Your Ref: OWPC22271
Our Ref: EP/25/19/HH 01-03-2019
Please ask for:
Zac Denton

Construction of single storey rear extension; extension of first floor roof space; internal re-ordering; replacement of garage roof; replacement of pitched roof covering; new porch and side canopy; elevational alterations and associated works
12 Westfield Avenue East Preston

Thank you for your internet representation made on 18th April 2019 which has been recorded as '**an objection**' with the comments as follows:

Elevations

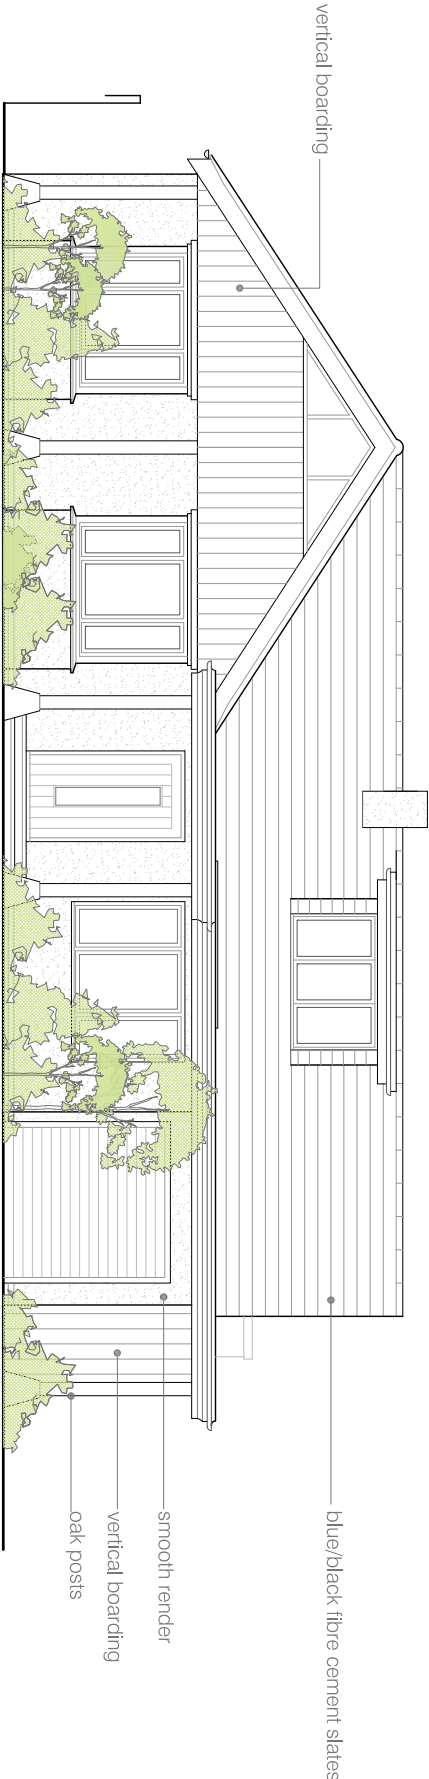
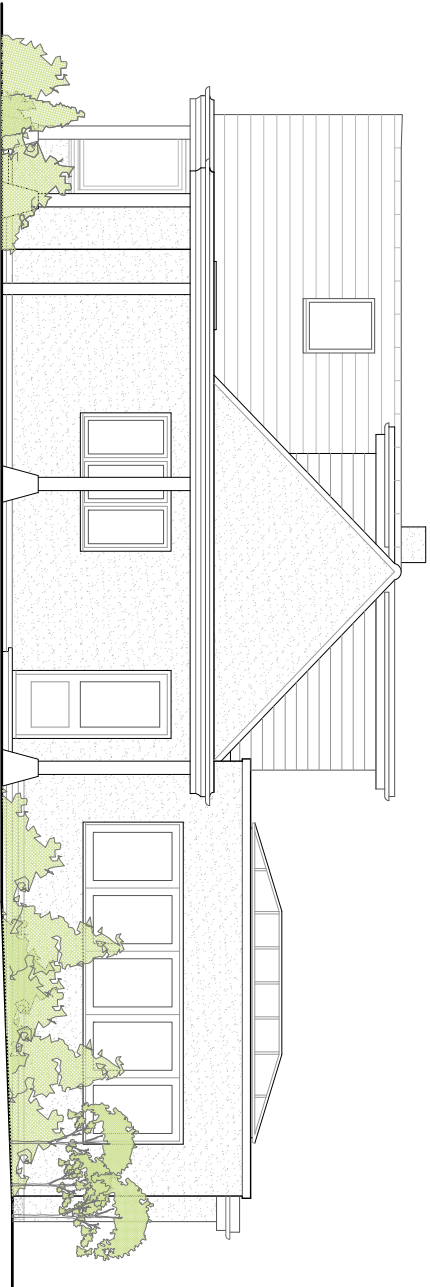
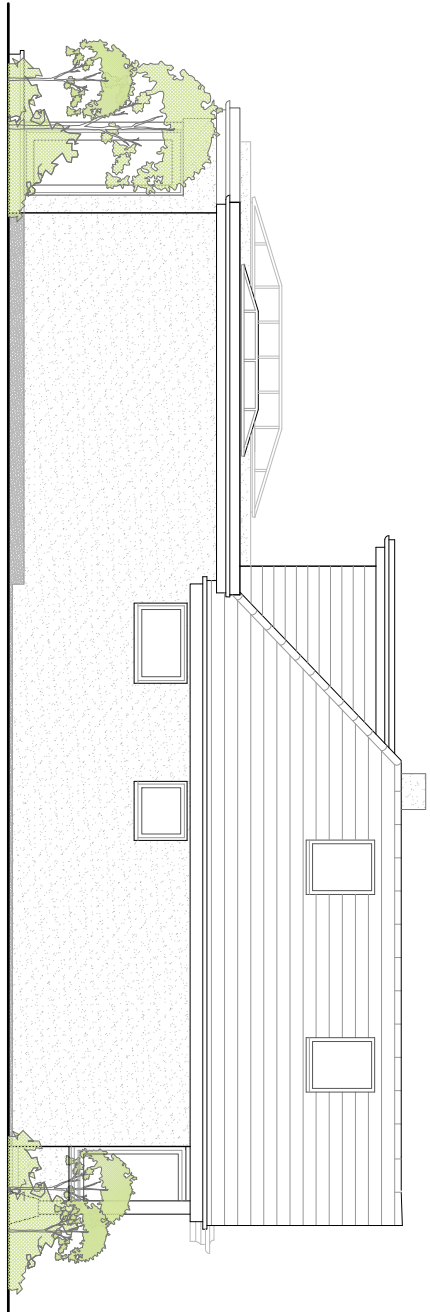
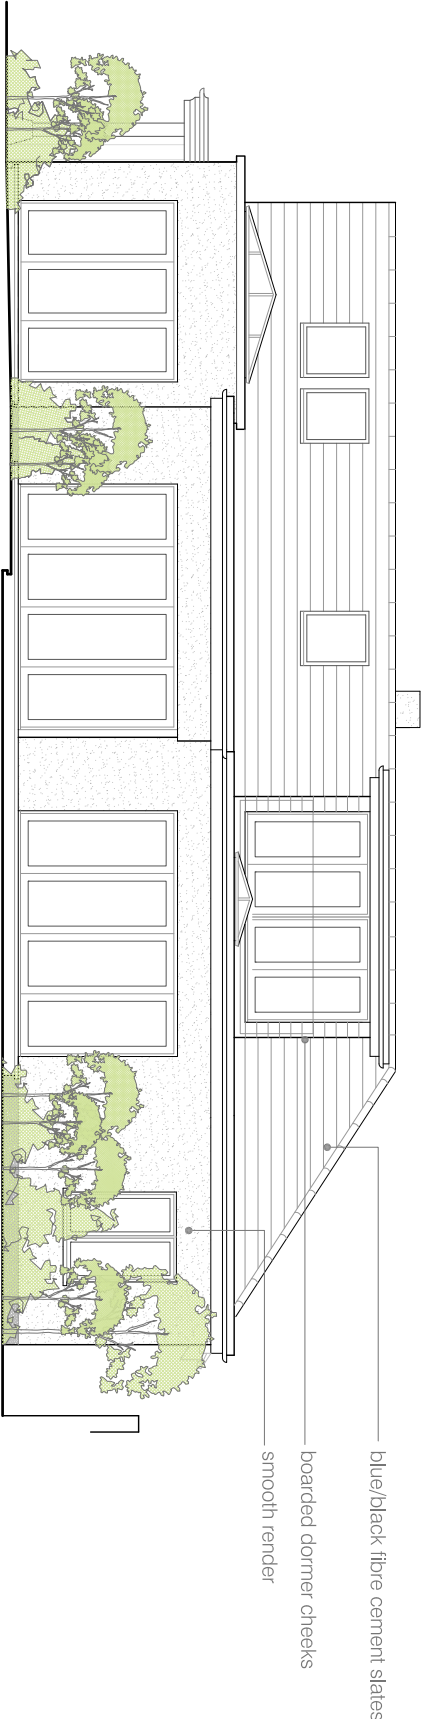
The proposed dormer window on the street front of the property is excessively high, reaching the ridge of the roof. It would therefore contravene Policy 1 of the East Preston Neighbourhood Plan, which specifies that dormer windows are acceptable if they are small enough to be subservient to the appearance of the roof as a whole. (para. 4.14).

The application also proposes to replace the existing roofing, which is reddish in colour, with blue-black fibre cement slates. Such a roofing material would differ from that of the neighbourhood, in which the predominant roofing material is the clay tile. This alteration would therefore conflict with Policy D DM1 of the Arun Local Plan and Policy 1 of the East Preston Neighbourhood Plan.
